**Planning Department
Transportation Development Services**

March 10, 2015

Re: Pasadena Office Warehouse
5656 Pasadena NE
Traffic Circulation Layout
Engineer's/Architect's Stamp dated 7/14/14 (B18-D019)

PROPOSED SITE PLAN

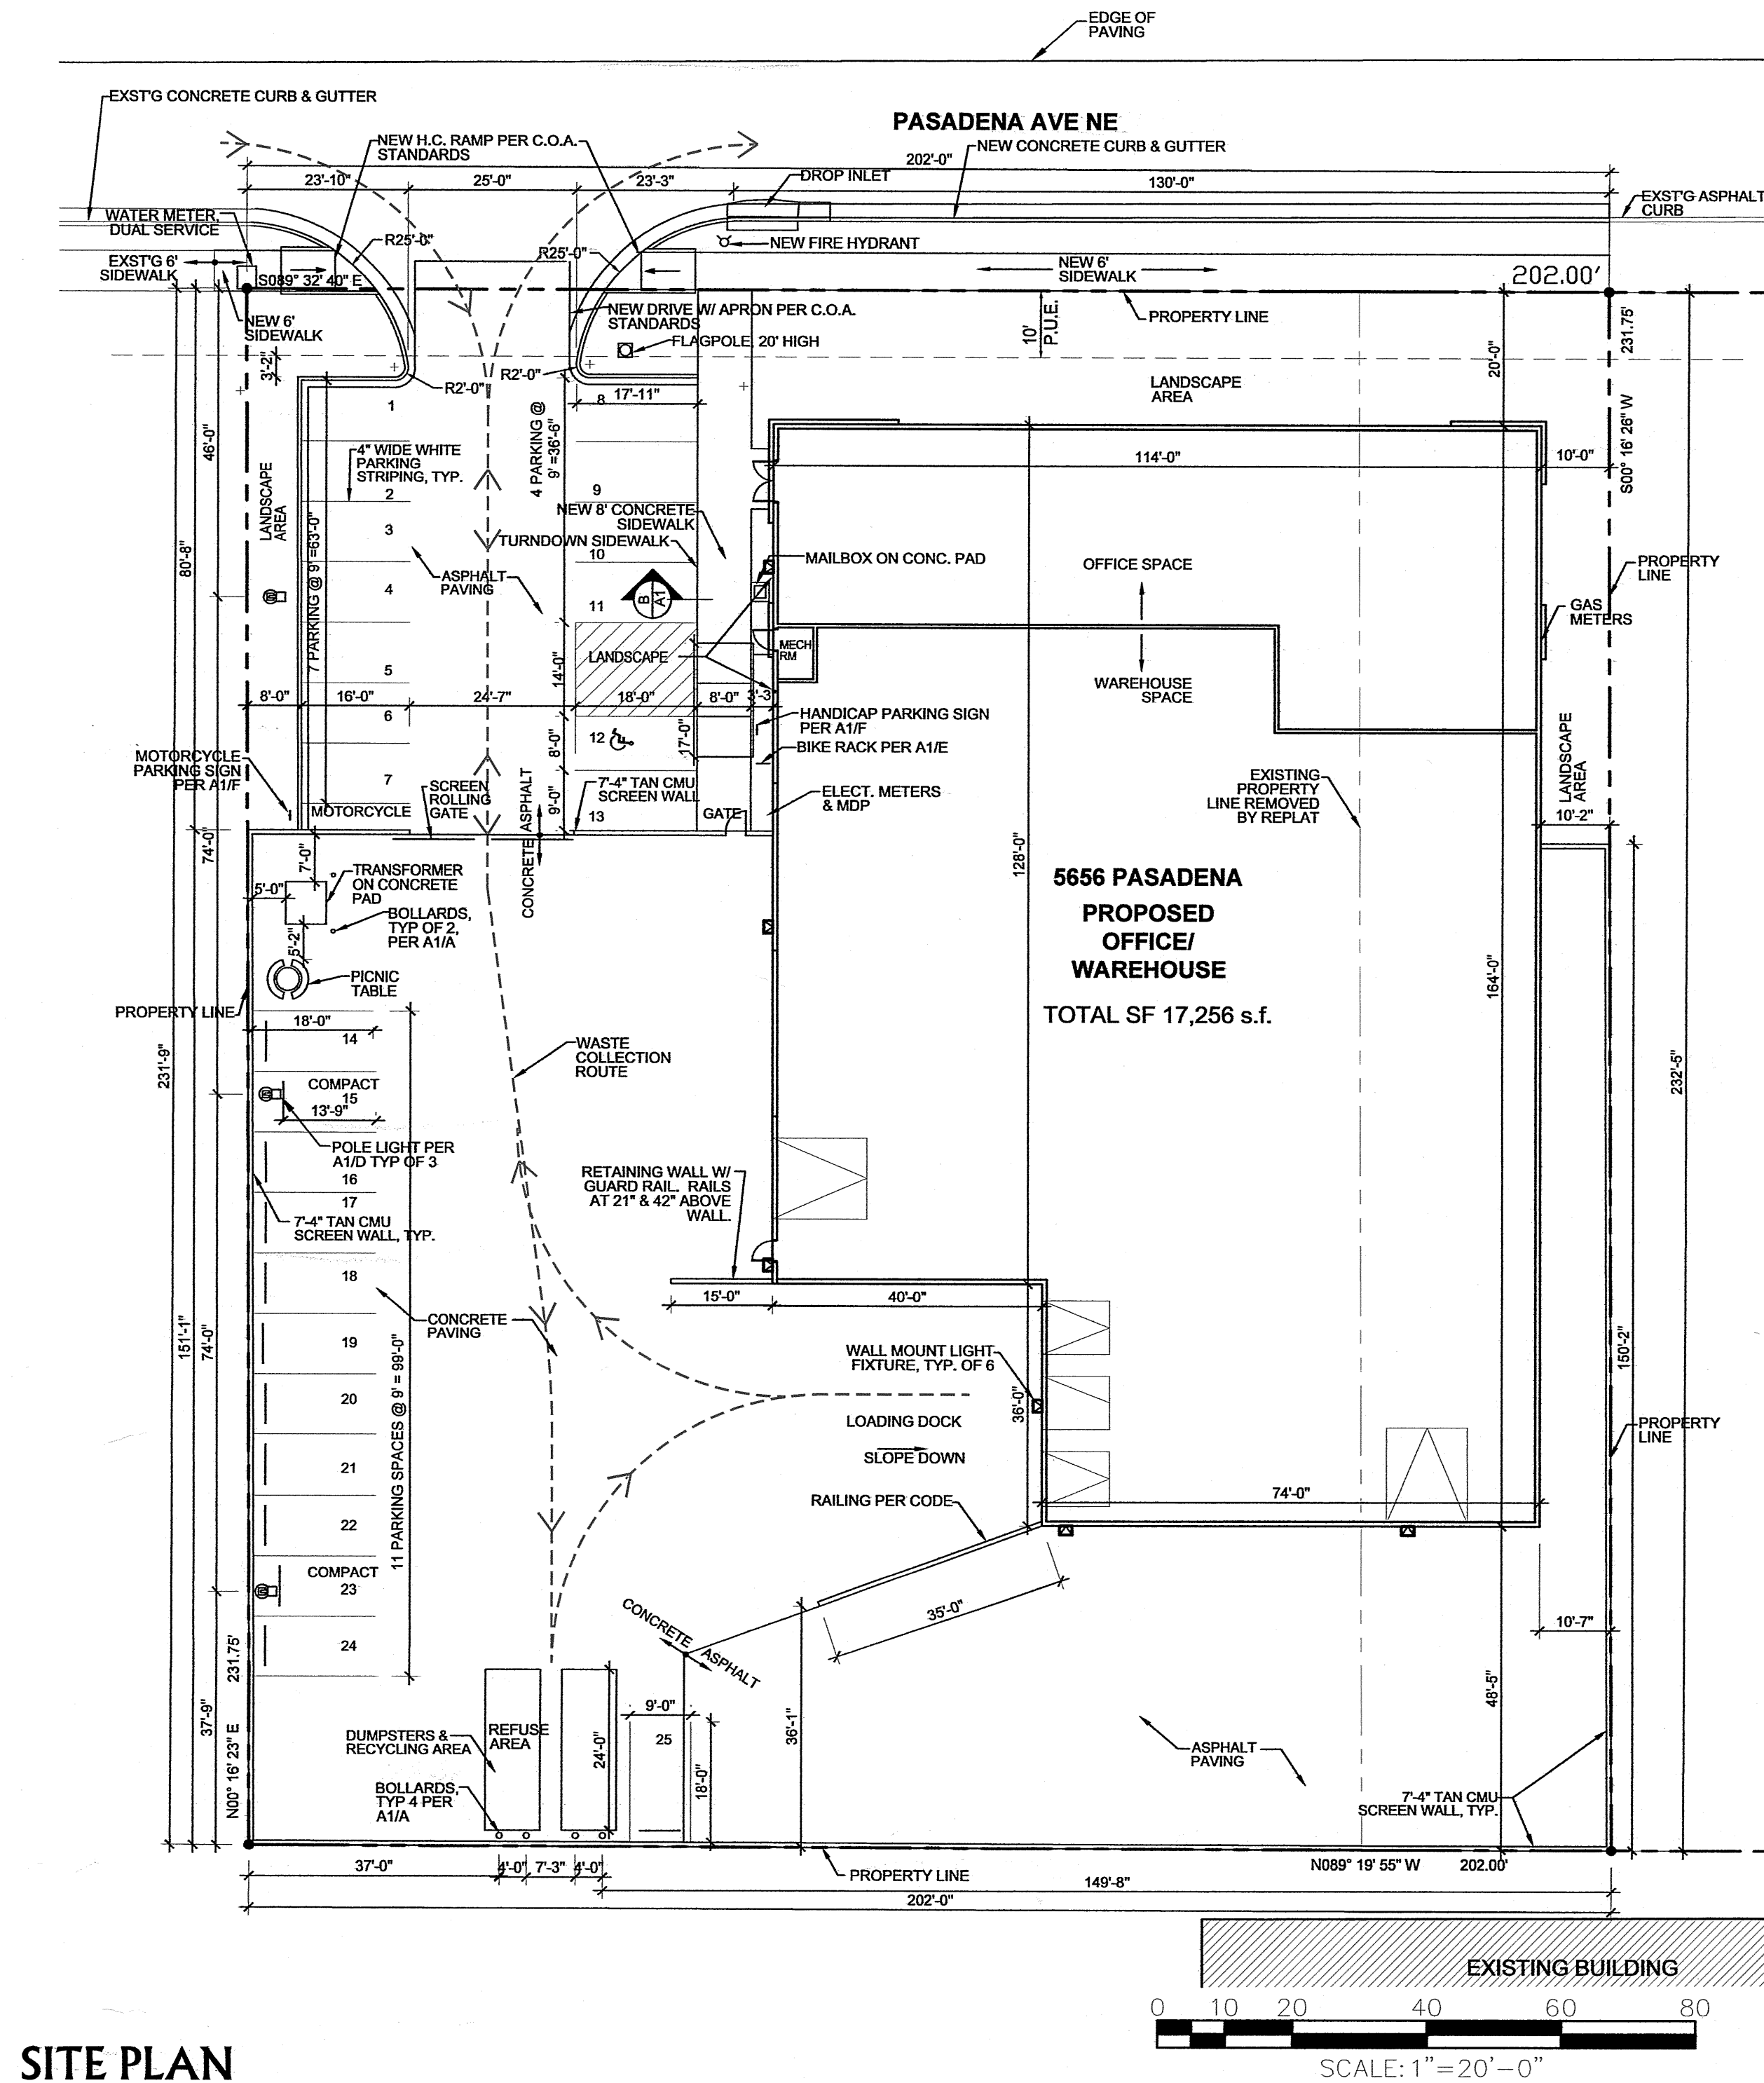
1. The handicap accessible spaces must include an 8-foot wide van access aisle; all other aisles should be 5 feet in width. The van accessible aisle must not be blocked in any way. Upon inspection, there were two bollards at the front end of van accessible aisle.

2. The ADA van accessible sign must have the required language per 66-7-352.4C NMSA 1978 **"Violators Are Subject to a Fine and/or Towing."**

3. The ADA access aisle shall have the words "**NO PARKING**" in capital letters, each of which shall be at least one foot high and at least two inches wide, placed at the rear of the parking space so as to be close to where an adjacent vehicle's rear tire would be placed. (66-1-4.1.B NMSA 1978)
4. Per the DPM, a 6 ft. wide ADA accessible pedestrian pathway is required from the public sidewalk to the building entrances. Upon inspection, this pathway is not provided. There is a stepped walkway from the public sidewalk to the building entrance. See picture below:
